**WELWYN HATFIELD BOROUGH COUNCIL
EXECUTIVE DIRECTOR - PLANNING, PUBLIC PROTECTION AND GOVERNANCE**

Application No: 6/2022/1854/HOUSE
Location: 78 Bell Lane Brookmans Park Hatfield AL9 7AY
Proposal: Erection of single storey extension to the flank garage with a flat roof
Officer: Ms Kirsty Shirley

Recommendation: Refused

CLIENT	Mr J Demetriou	Proposal	Proposed & Existing Elevations & Layouts
LOCATION	78 Bell Lane Brookmans Park AL9 7AY

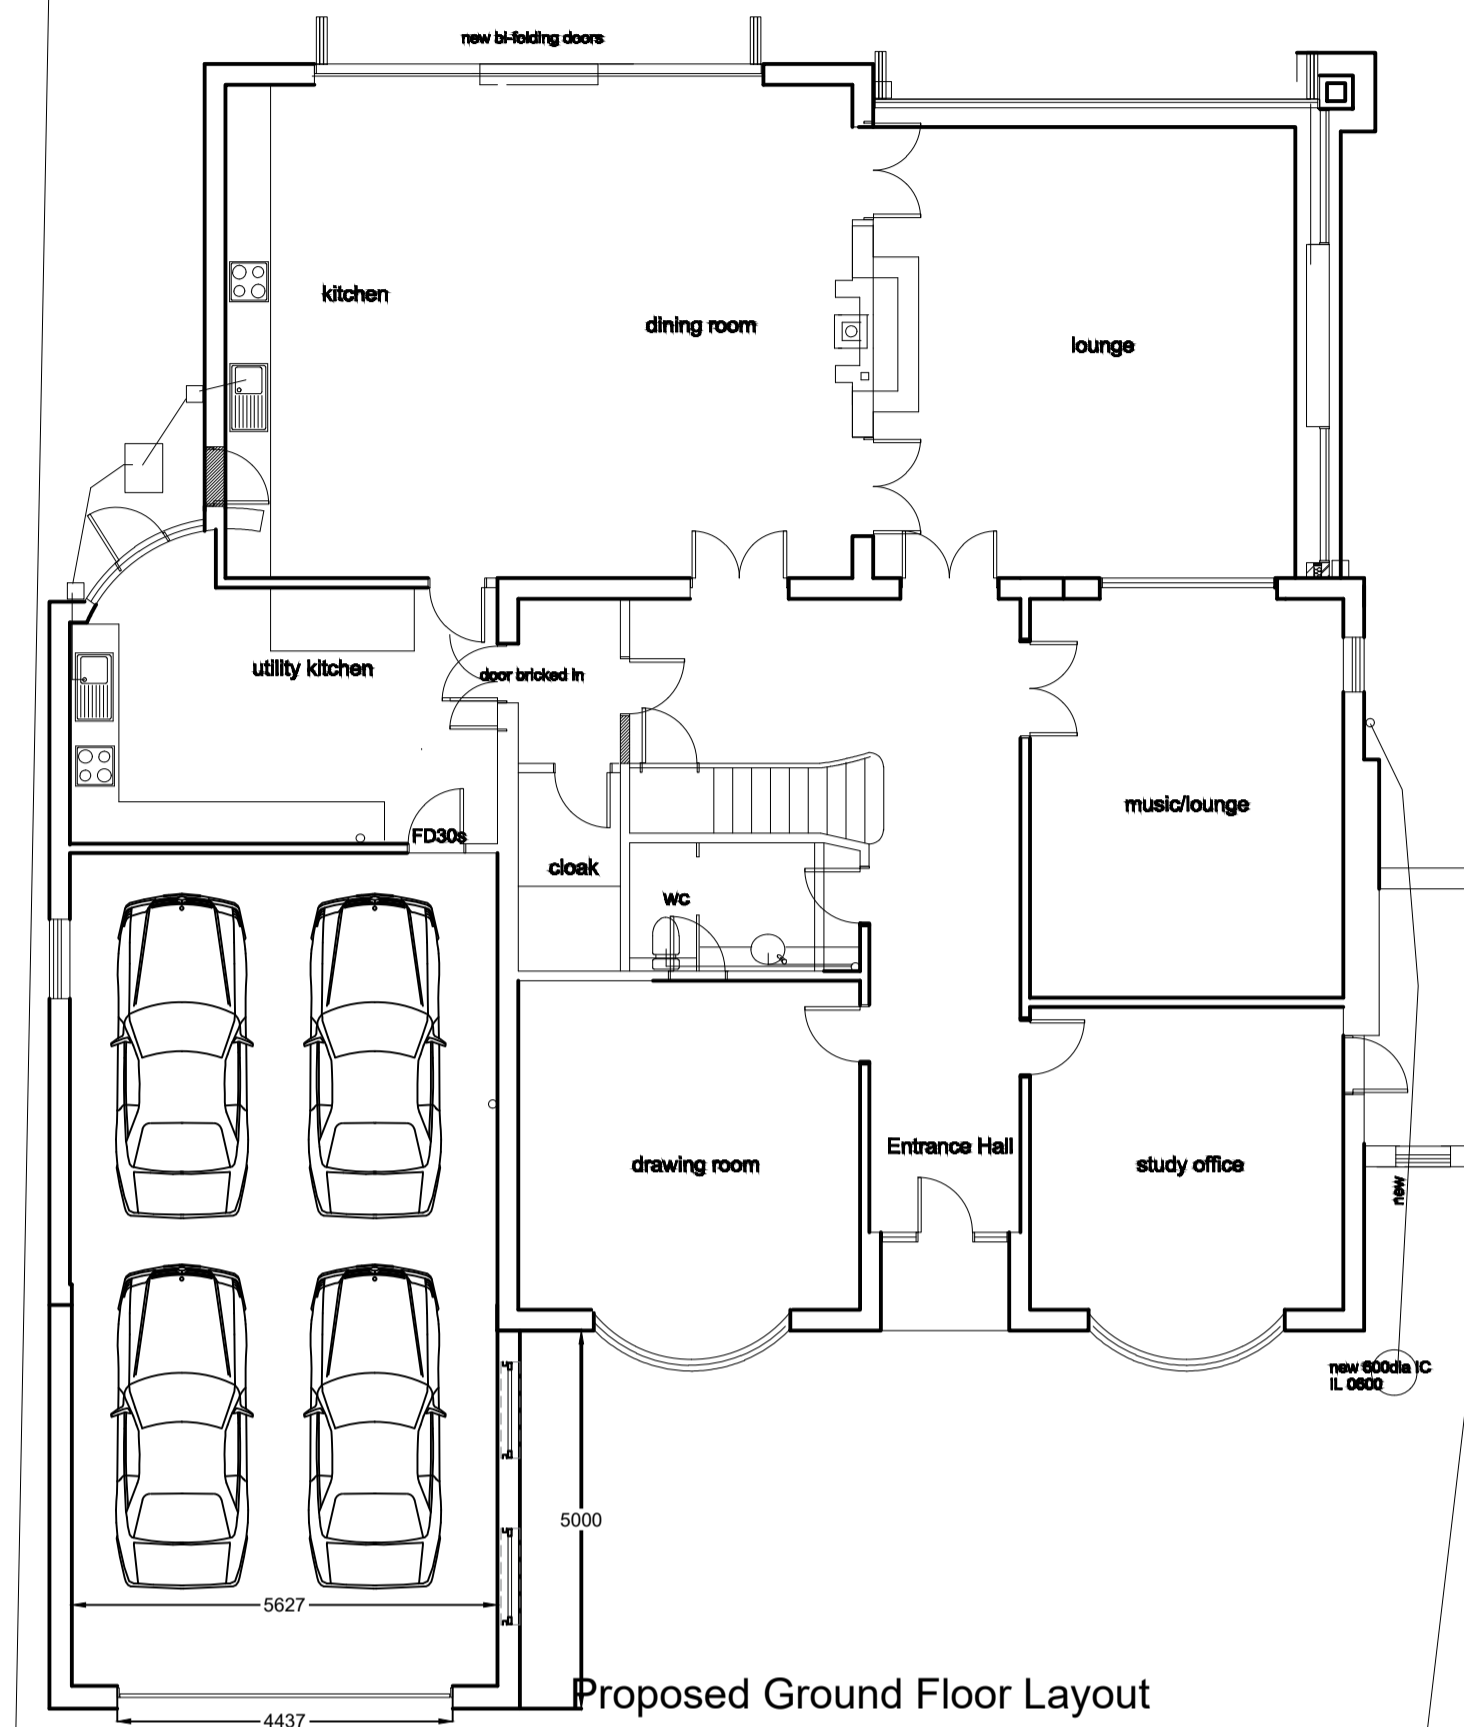
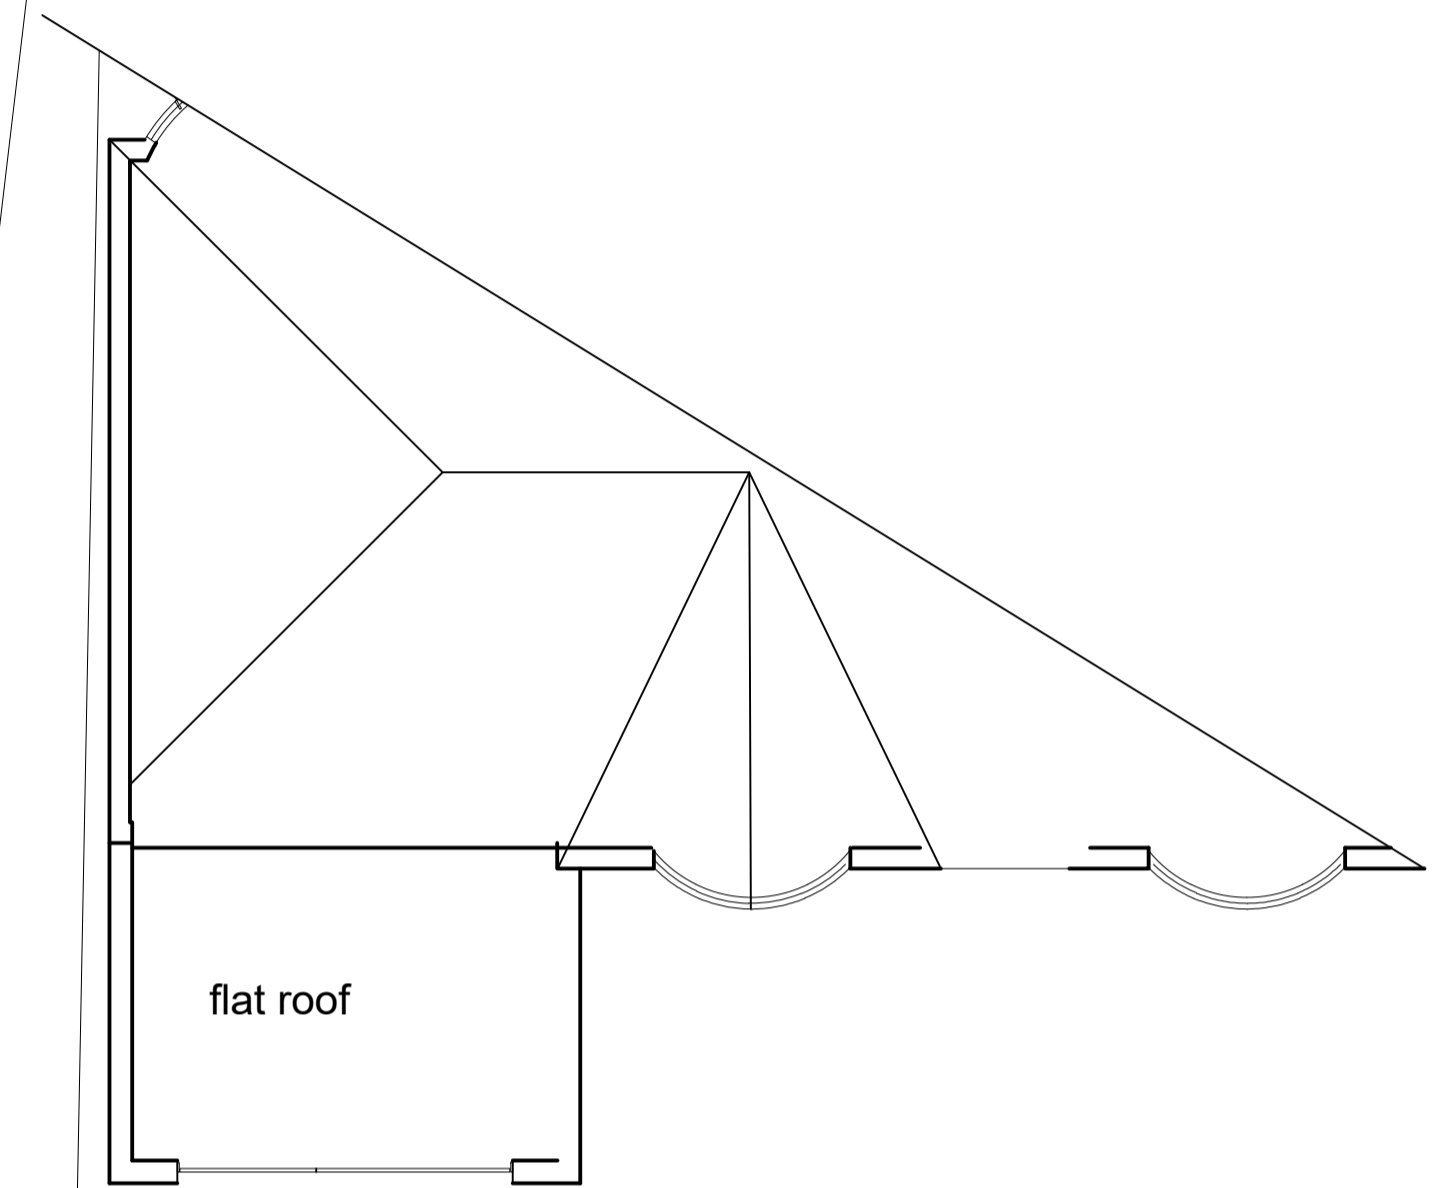
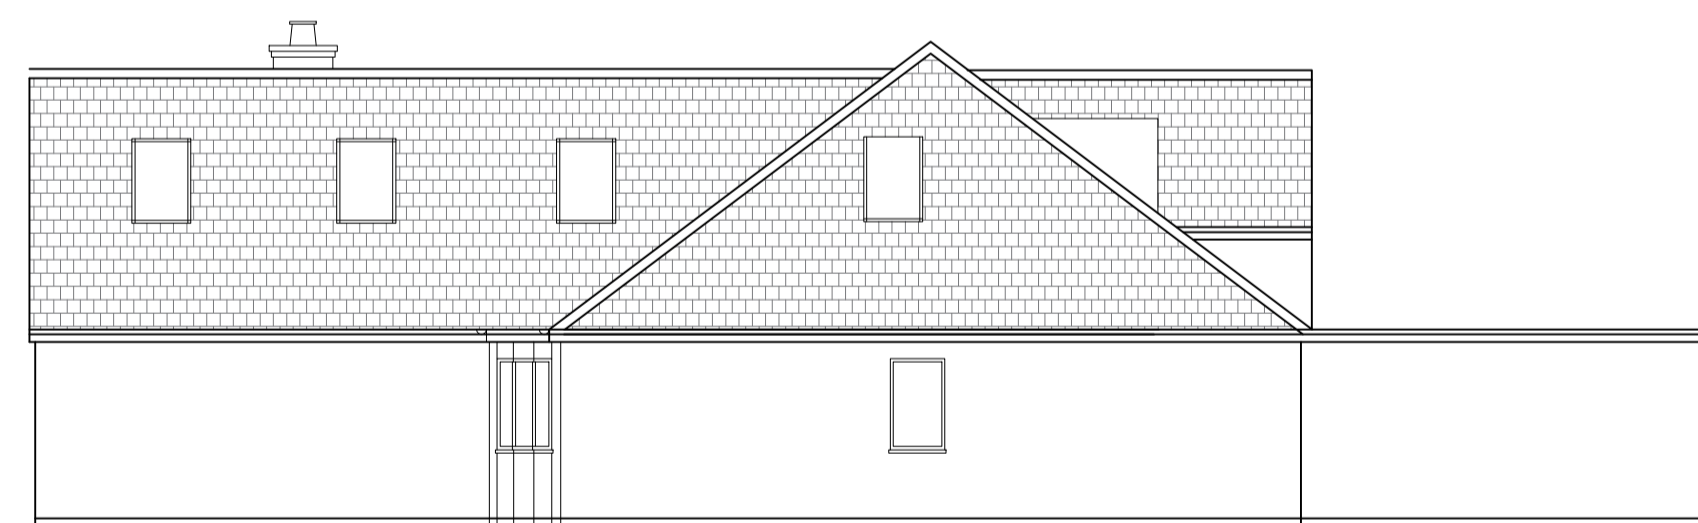
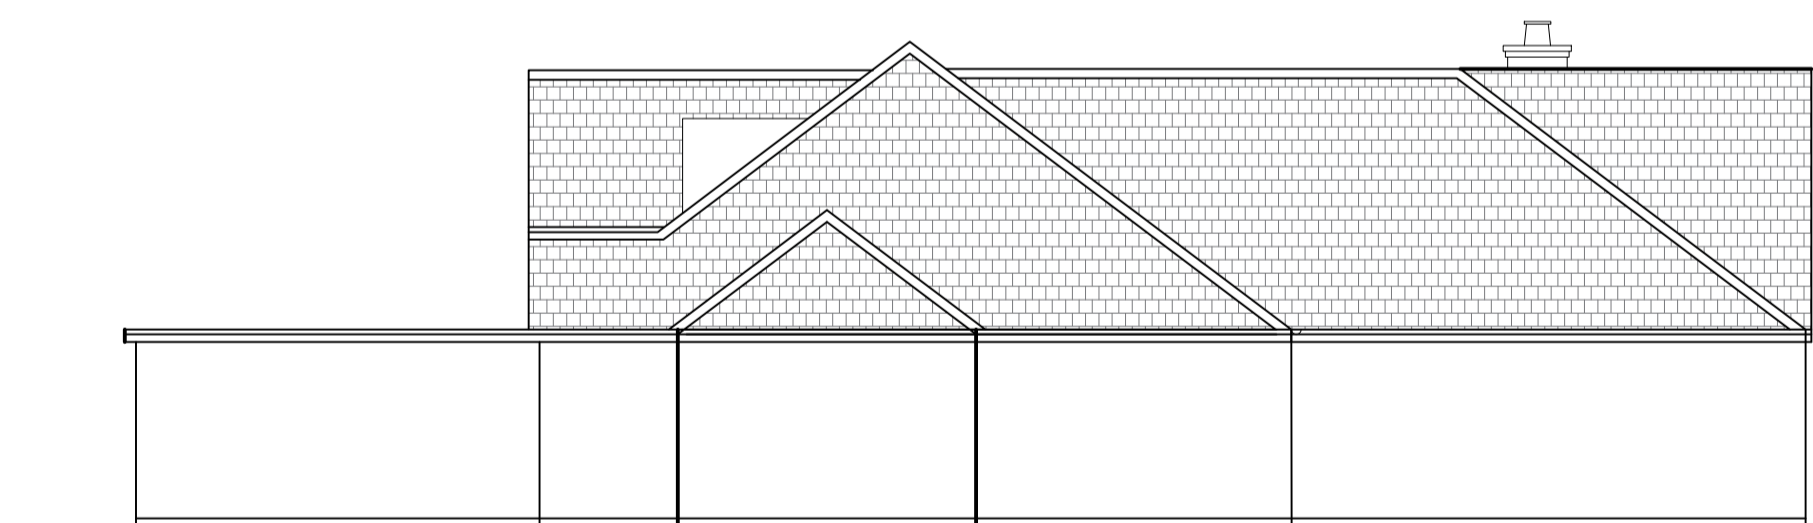
The proposed extension would result in the property being extended to its front with a single storey extension which would project approximately 5m beyond the front elevation. The proposed development would result in the creation of approximately 32m² of new floor space. This addition, taken cumulatively with the existing additions, would represent approximately 170% increase above the floorspace of the original house. On a purely mathematical calculation the extensions to the original building would be disproportionate. However, in addition to mathematical calculations the visual impact of the extensions has to be considered.

There is no definition of openness in the NPPF but, in the Green Belt context, it is generally held to refer to freedom from, or the absence of, development. Further to the above discussions about the cumulative additions to the size of the building, it is considered that the proposed extension would have a harmful impact on the openness of Green Belt. The design, character and appearance of the proposed extension would not be consistent with the general pattern of development and character of the area. The increased bulk and massing of the proposal, together with its closer proximity to the highway, would result in the application dwelling appearing significantly larger and more prominent from

<p>public vantage points. The result would be a loss of openness and visual permeability of the Green Belt. The essential characteristics of Green Belts are their openness and their permanence and the loss of openness in the Green Belt resulting from the proposed extensions would conflict with this essential characteristic.</p>
<p>Design (form, size, scale, siting) and Character (appearance within the streetscene)</p>	<p>Policies D1 and D2 require the standard of design in all new development to be of a high quality and that all new development respects and relates to the character and context of the area in which it is proposed, maintaining and where possible enhancing the character of the existing area. These policies are expanded upon in the Council's Supplementary Design Guidance (SDG) which requires the impact of a development to be assessed giving regard to the bulk, scale and design of the proposal and how it harmonises with the existing building and area.</p> <p>In terms of the character of the area, paragraph 2.4 of the SDG outlines, amongst other things, that new development should:</p> <ul style="list-style-type: none"> - Respond to building forms and patterns of existing buildings in the detailed layout and design to reinforce a sense of place; - Use local materials and building methods/details to enhance local distinctiveness; and - Ensure that the scale, height, massing, and space around the new development in relation to the adjoining buildings is considered <p>The revised National Planning Policy Framework (NPPF) has a stronger emphasis on good quality design than its predecessor. Paragraph 126 clearly advises that the creation of high quality, beautiful and sustainable buildings and places is fundamental to what the planning and development process should achieve and that good design is a key aspect of sustainable development. Paragraph 130 of the NPPF further advises that decisions should ensure developments will function well and add to the overall character of the area, be visually attractive, sympathetic to local character and establish a strong sense of place. Paragraph 134 is clear that <i>“Development that is not well designed should be refused, especially where it fails to reflect local design policies and government guidance on design, taking into account any local design guidance and supplementary planning documents such as design guides..”</i></p> <p>The proposed extension would project approximately 5m from the front elevation of the dwelling, with a width of approximately 6.3m. The extension would feature a flat roof.</p> <p>The flat roof of the extension would appear discordant with the hipped roof and intersecting hipped and gable features within the roof of the dwelling. This discordance would be further emphasised as a result of the positioning and scale of the extension. The bulk and massing of the extension to one side of the front elevation would be a substantial and a predominant feature at the front of the dwelling. The bulk and massing of the extension would fail to respect and relate to the appearance of the existing dwelling, and the discordance of the extension would detract from the character of the area.</p> <p>It is therefore considered that the proposed development, by virtue of the</p>

<p>extensions positioning, scale and design, would result in a discordant and overbearing addition to the dwelling that would fail to complement and reflect the design and appearance of the application dwelling. Accordingly, the proposed development represents a poor standard of design which is harmful to the appearance of the application dwelling and the character of the area, contrary to Policies D1 and D2 of the Welwyn Hatfield District Plan; Policies SP9 and SADM11 of the Emerging Local Plan; the Supplementary Design Guidance; and the National Planning Policy Framework.</p>
<p>Impact on neighbours</p>	<p>No neighbour representations have been received.</p> <p>Due to the size and positioning of the extension, it is considered that the neighbour that is most likely to be affected by the proposal would be adjoining neighbour No. 80 Bell Lane. The extension would be in close proximity to the shared boundary between No. 80 and the application dwelling and would extend along this boundary for approximately 5m.</p> <p>In terms of privacy, no windows would be inserted into the extension, and the privacy of the occupiers of No. 80 would therefore be maintained.</p> <p>The existing relationship between No.80 and the application dwelling means that the nearest ground floor front facing window serving No. 80 is positioned from the existing front elevation of the application dwelling by approximately 6m. The extension would project just shy of 5m beyond the existing front elevation of the application dwelling and would have a height of approximately 2.7m. The positioning and massing of the extension would exasperate the deficiency in the relationship between No. 80 and the application dwelling, with the orientation of the extension compounding this impact on No. 80. The extension would therefore appear unduly dominant and overbearing towards the occupiers of No. 80.</p> <p>The application dwelling and No. 80 face broadly north-west, experiencing shadowing at the front of the properties for most of the day in winter. The positioning of the extension would result in the front facing ground floor window of No. 80 to receive less light briefly in winter. However, such a loss of light would be for an extended period in the summer months, and as such, the extension would result in the occupiers of No. 80 to experience a detrimental loss of light.</p>

2. The proposed development, by virtue of the extensions positioning, scale and design, would result in a discordant and overbearing addition to the dwelling that would fail to complement and reflect the design and appearance of the application dwelling. Accordingly, the proposed development represents a poor standard of design which is harmful to the appearance of the application dwelling and the character of the area, contrary to Policies D1 and D2 of the Welwyn Hatfield District Plan; Policies SP9 and SADM11 of the Emerging Local Plan; the Supplementary Design Guidance; and the National Planning Policy Framework.

3. The proposed development, due to the scale, bulk and siting of the extension, would unacceptably harm the amenity and living conditions of the occupiers of No.

80, through loss of light to habitable rooms and an overbearing presence of built form close to the shared boundary between the application site and No. 80.
